Our Reference: SYD13/00293/01
Your Reference: 05_0157

**MATERIALS RECYCLING FACILITY – MOOREBANK (05_0157)
LOT 6, DP 1065574**

Below are the Committee's recommendations and RMS's requirements on the subject application:

SWEPT PATH DIAGRAM FOR 15M A.V TURNING TO AND FROM BRICKMAKERS DR		DESIGN		LMA		SHEET No.		DRAWING No.			
																FROM THE ACCESS ROAD TO MOOREBANK RECYCLERS VIA THE LINK ROAD		DRAWN		EMMC		1D		8318/7/09	
																		CHECKED		GLM		OF		8

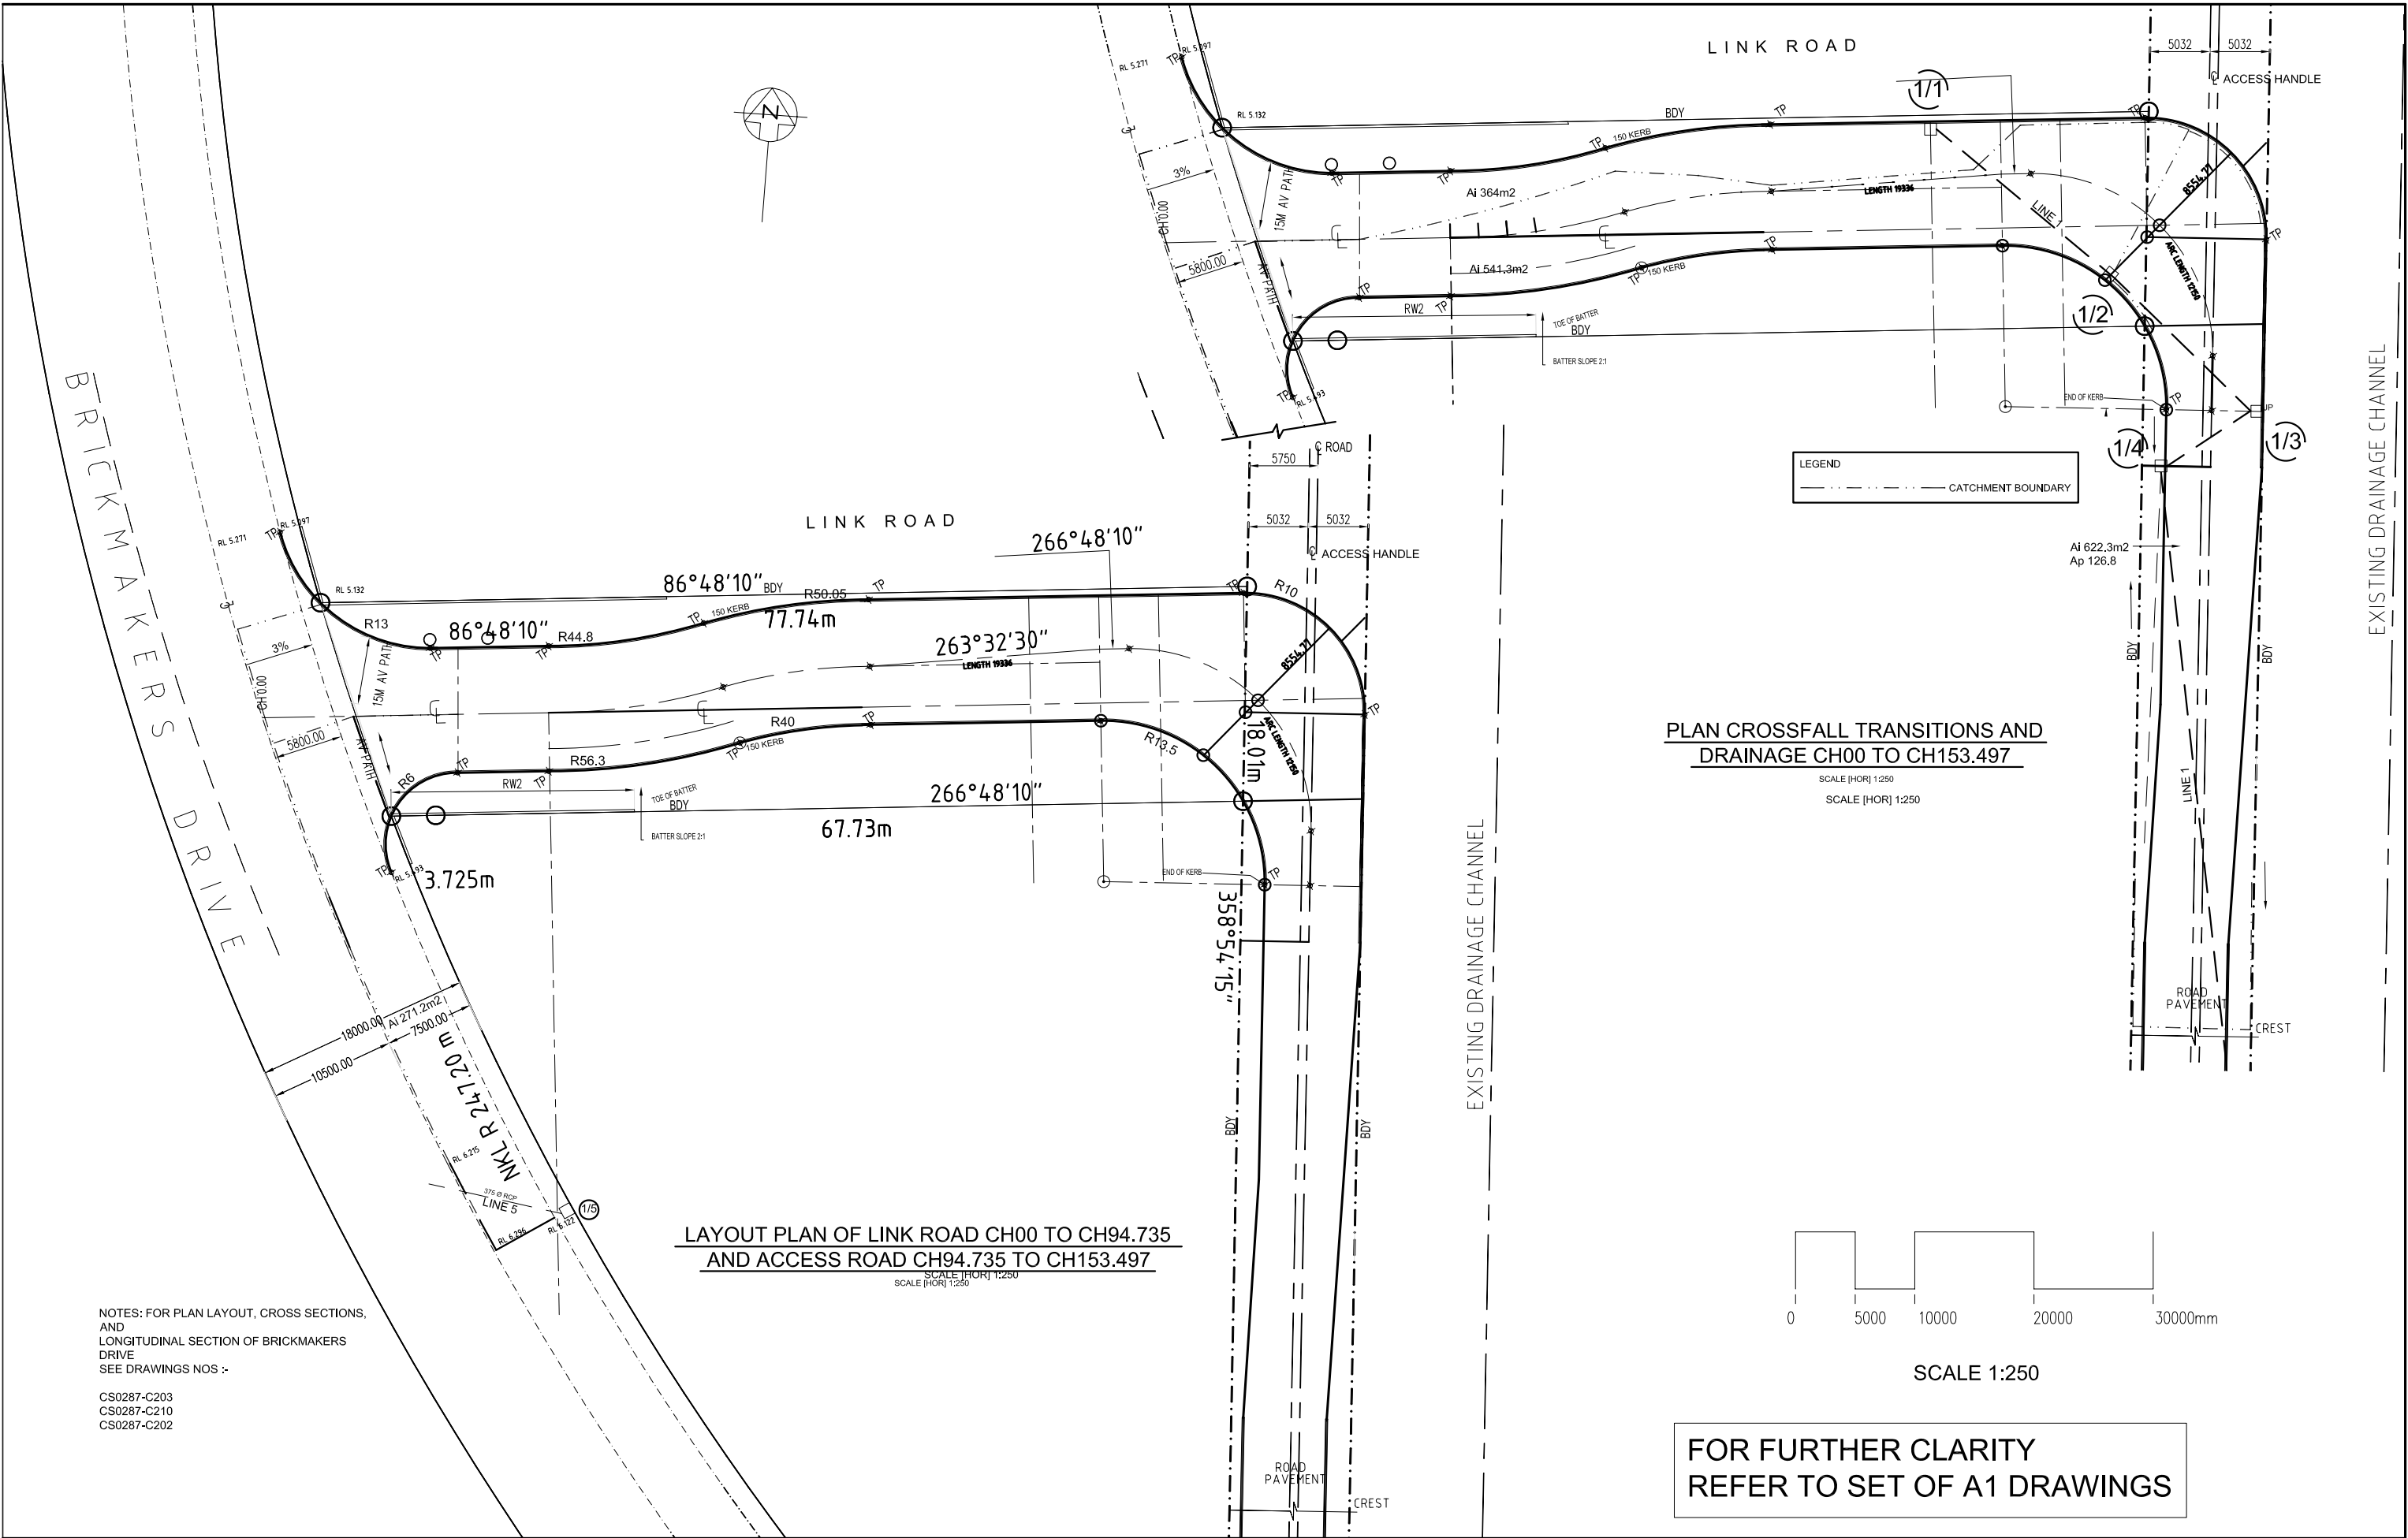
5. The swept path of the longest vehicle entering and exiting the subject site, as well as manoeuvrability through the site, shall be in accordance with AUSTROADS. It is noted that the turning paths shown on plan 8318/7/09 sheet 1D of 8 don't comply with Austroads Guide.
